From: James Darwin <James@georgiangroup.org.uk>
Sent: 26 April 2019 11:15
To: Development Control
Cc: James Darwin
Subject: Your ref: 19/00334/LBC & 19/00333Ful – Land to the north of Castle Street and South east of Waterhouse Lane including Castle Buildings and the former Earl de Grey Public House, Kingston upon Hull.

Thank you for informing the Georgian Group of development proposals which include the dismantling and rebuilding of the grade II listed former Earl De Grey Public House. After carefully reading the supporting documents provided, The Group wishes to forward the following brief initial comments.

Fig 9: Earl de Grey Ground Floor Plan (approx. extent of listing in red)

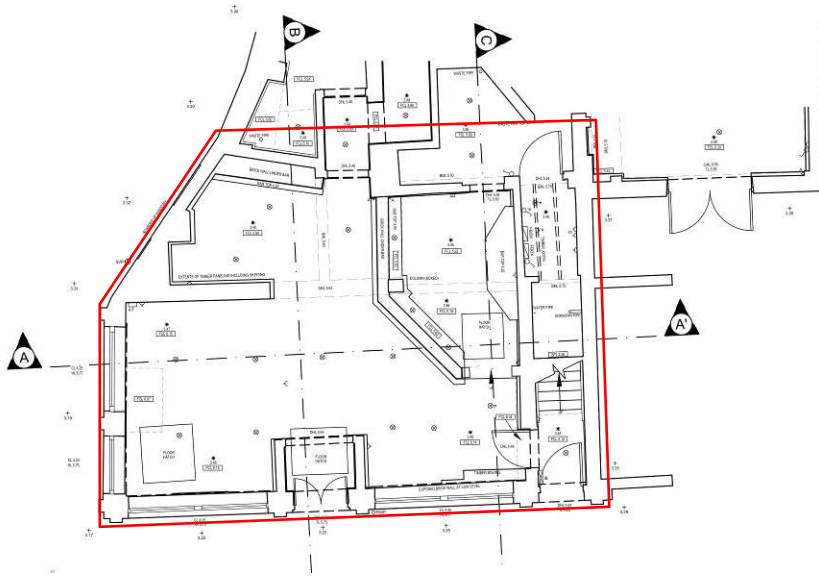
The location of the proposed new staircase should be moved in order to allow the original function of the former bar area to be more clearly read (and if possible, for this function to be reinstated at a future date). The location and size of the presently proposed stair may act as a deterrent for certain types of business and thus limit options for the building's long-term use. Moving the proposed stair would thus help to safeguard the re-erected structure's significance and improve its long-term viability.
